Environmental Statement Consolidated Errata and Changes

Hinkley Point C Connection Project

ES VOLUME 5.30B.1 – ENVIRONMENTAL STATEMENT CONSOLIDATED ERRATA AND CHANGES DOCUMENT

SHEET 16 of 50

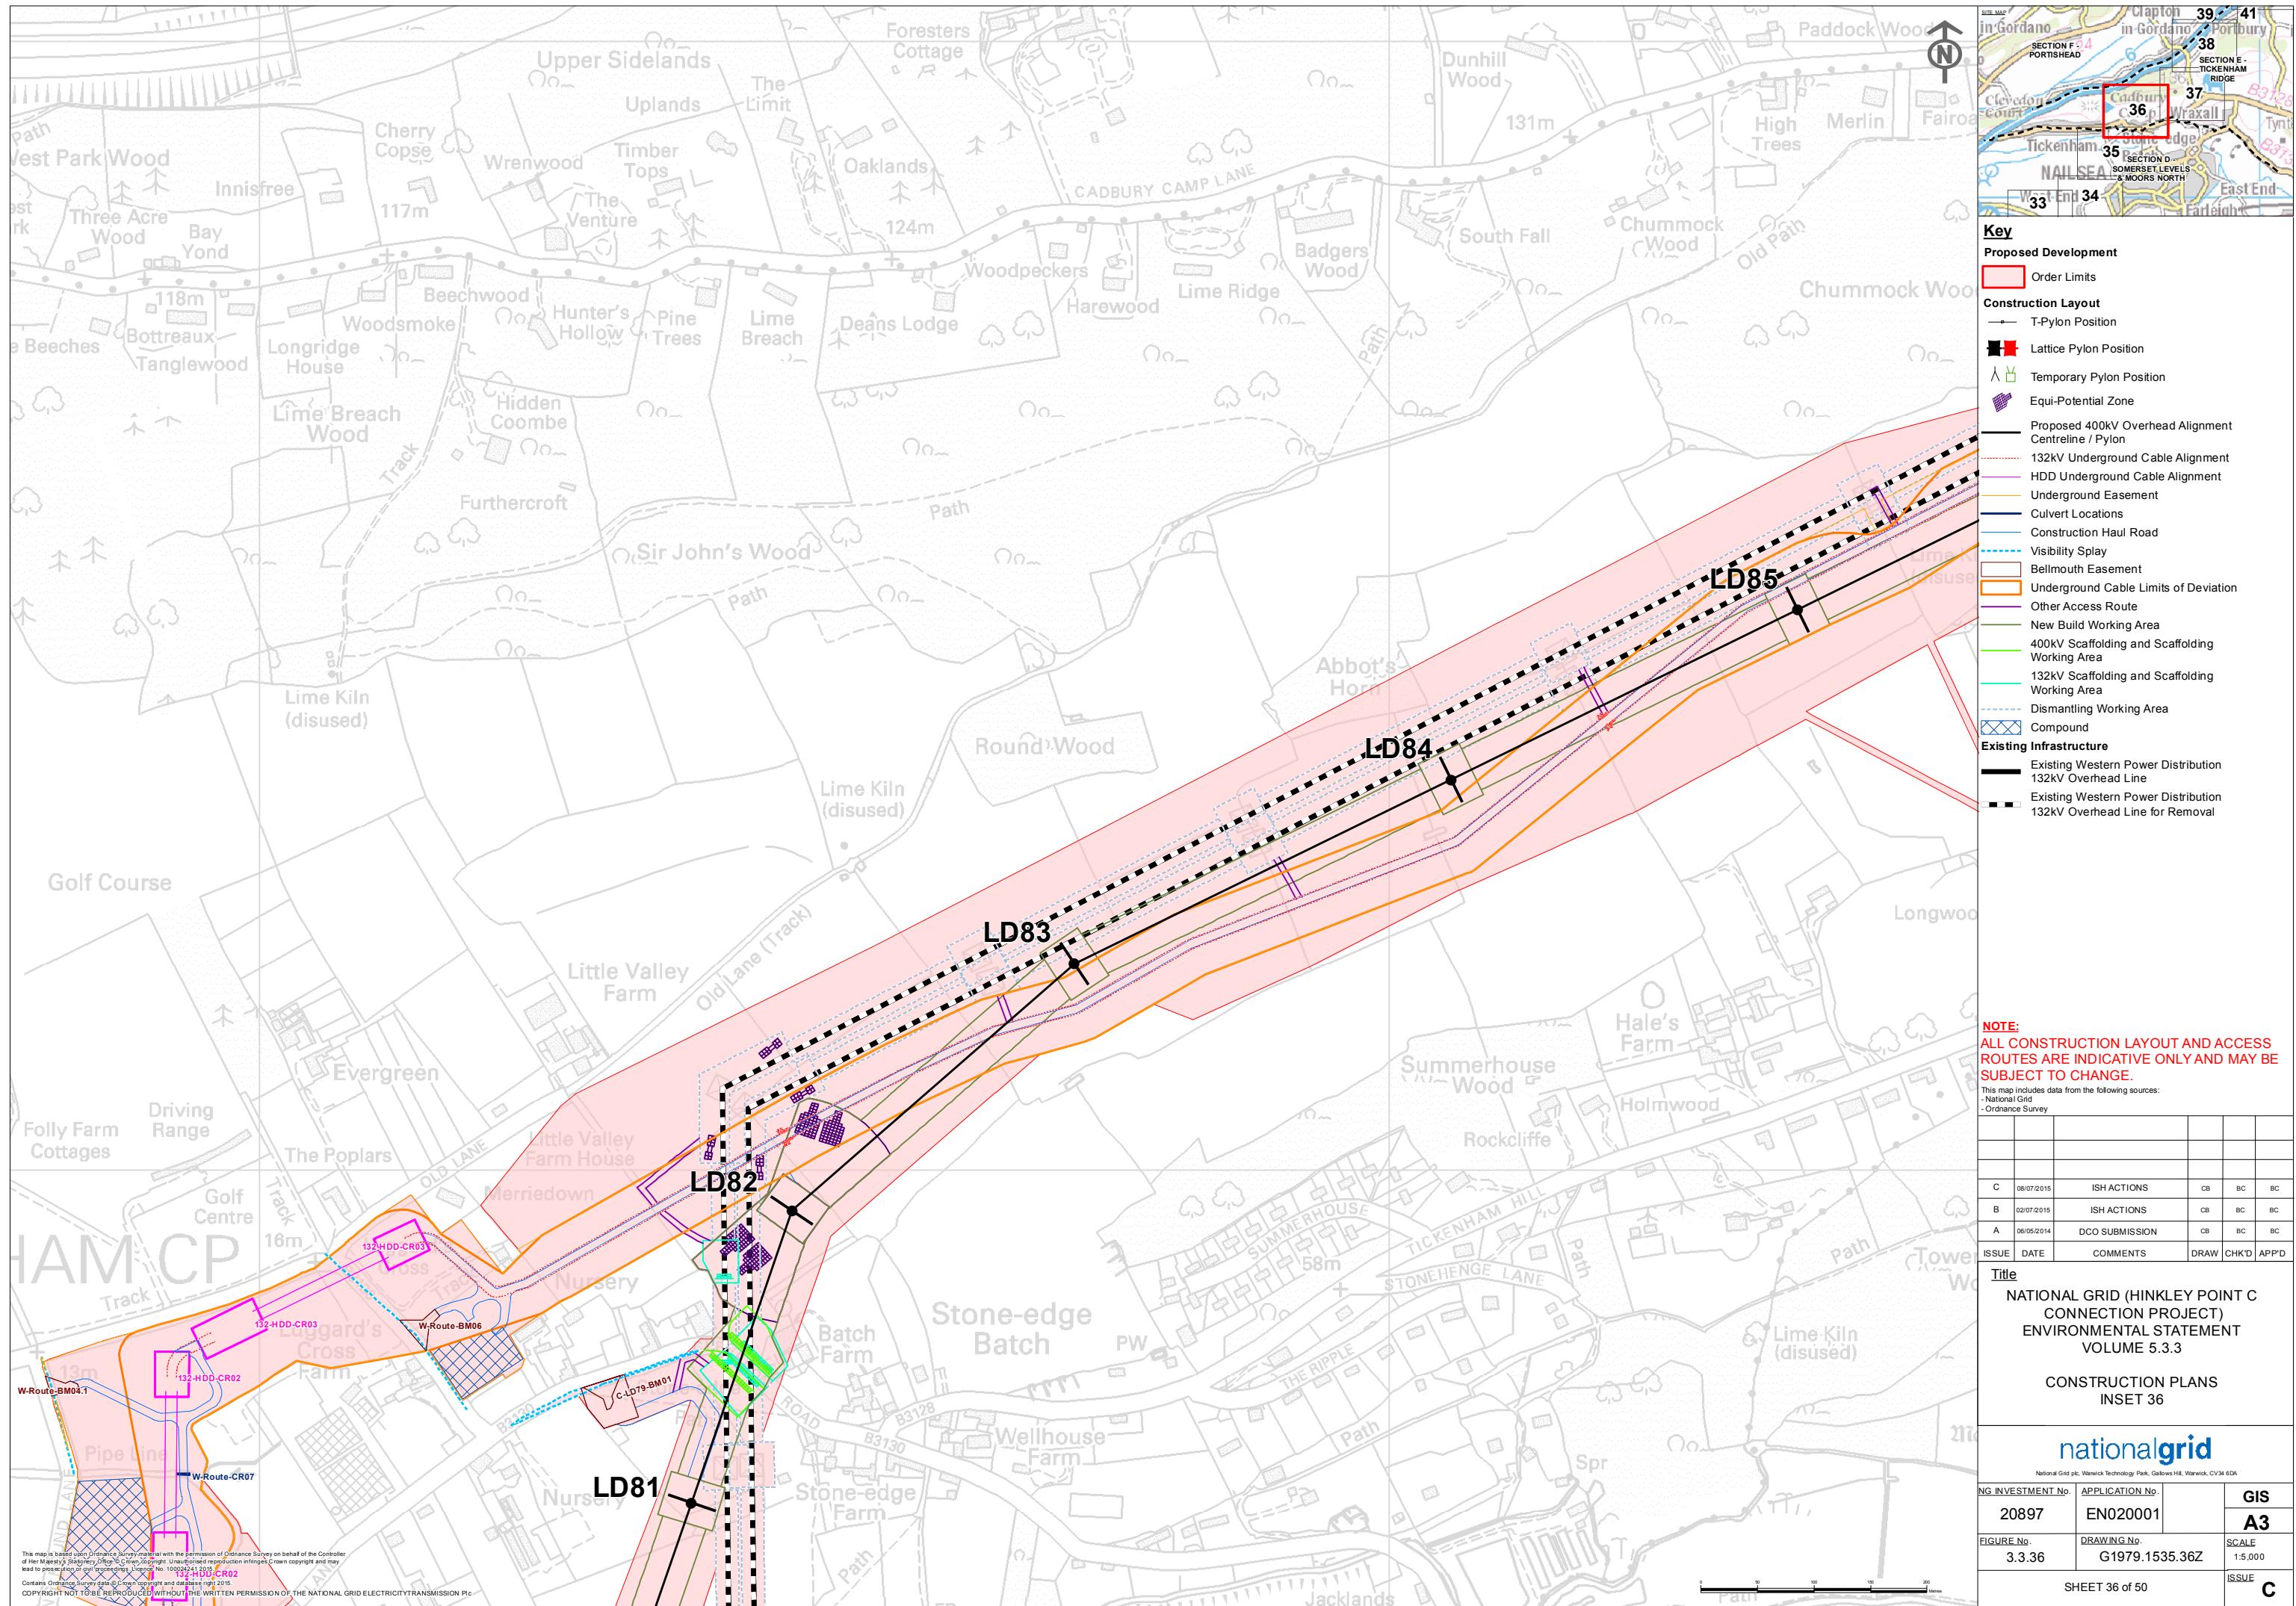
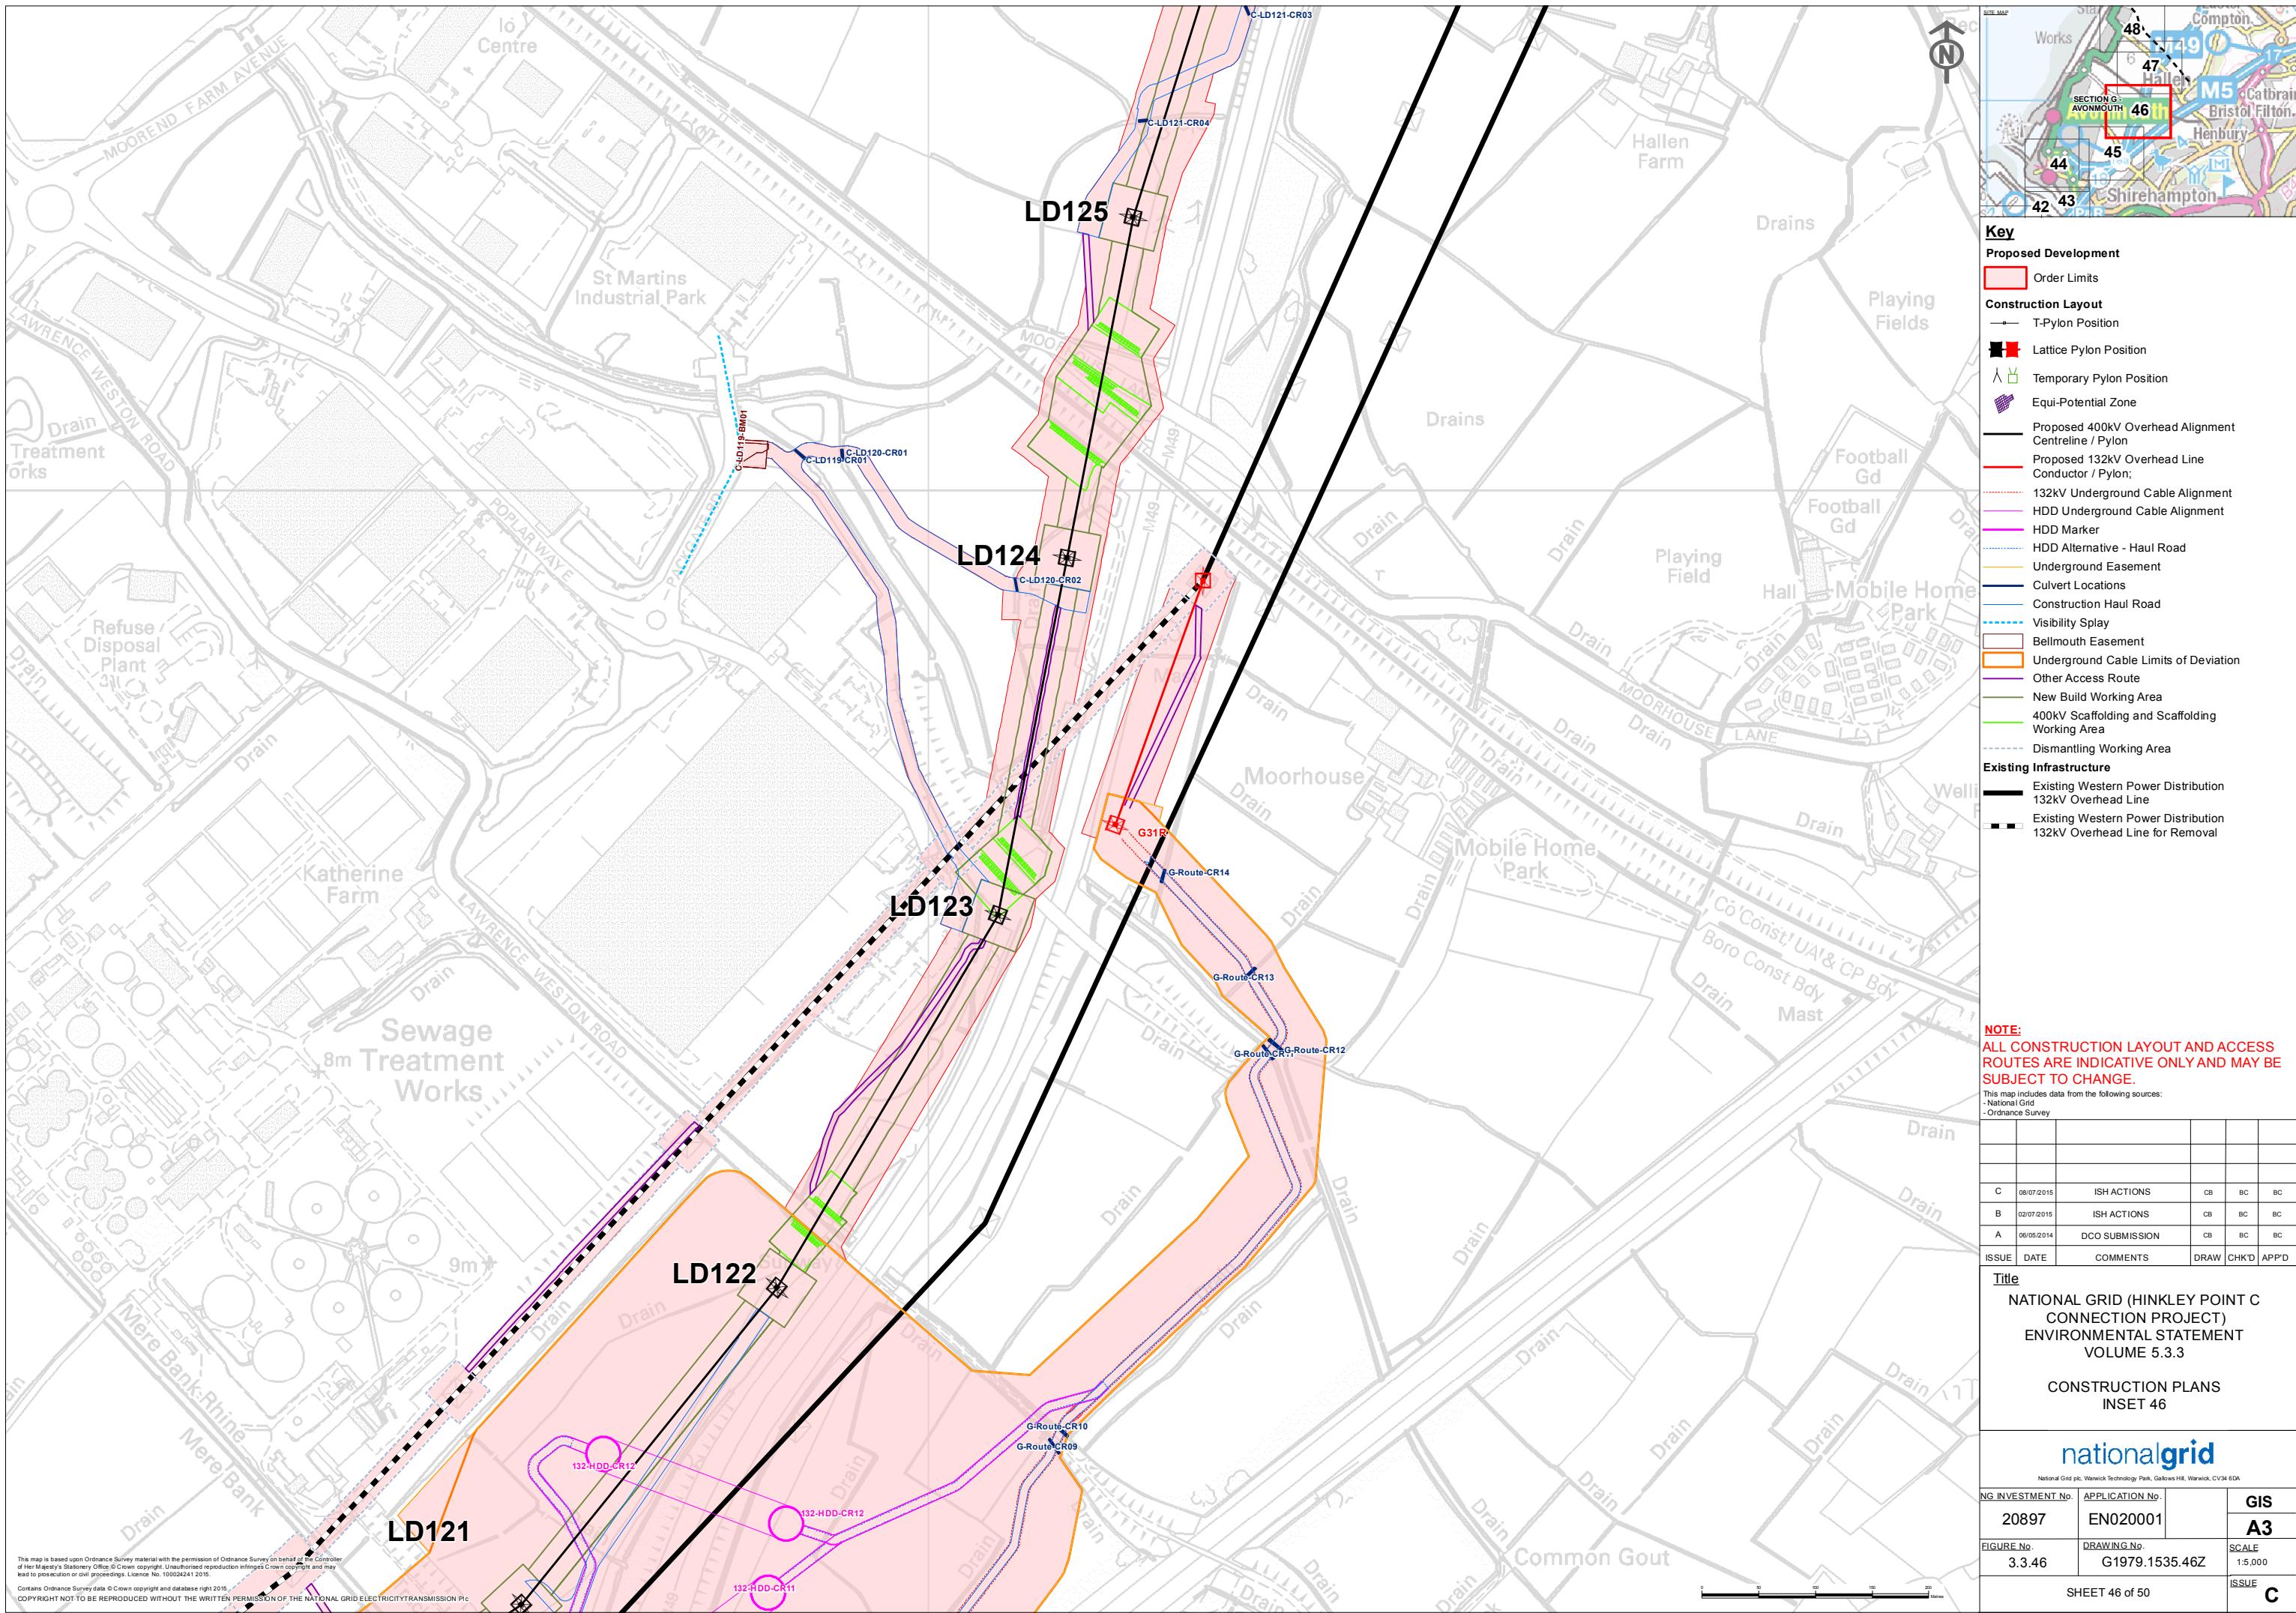
ES Volume 5.3.2, Appendix 3E ES Volume 5.3.3.2, Figures 3.3.16, 3.3.28, 3.3.35, 3.3.36, 3.3.49 and 3.3.50	<p>ES Volume 5.3.2, Appendix 3E (Bellmouth Schedule) should be read as amended due to a variety of changes discussed during the Issue Specific Hearings as follows:</p> <ul style="list-style-type: none"> • Fletchers Lane – two additional bellmouths (400-UG-BM01A and 400-UG-BM01B) added to provide safe access across adopted highway. • Moorland Park – existing bellmouth (C-LD39-BM01) relocated due to the realignment of the proposed construction access (see below) north of Moorland Park. • Clevedon Road – existing bellmouth (W-Route BM05) removed. • Whitewick Lane – existing bellmouths (ZZ7-BM01 and ZG7-BM01) removed. <p>ES Volume 5.3.3.2, Figures 3.3.16, 3.3.28, 3.3.35, 3.3.36, 3.3.49 and 3.3.50 (Construction Plans) should be read as amended by Annex B of this document.</p>	Issues raised at Issue Specific Hearings
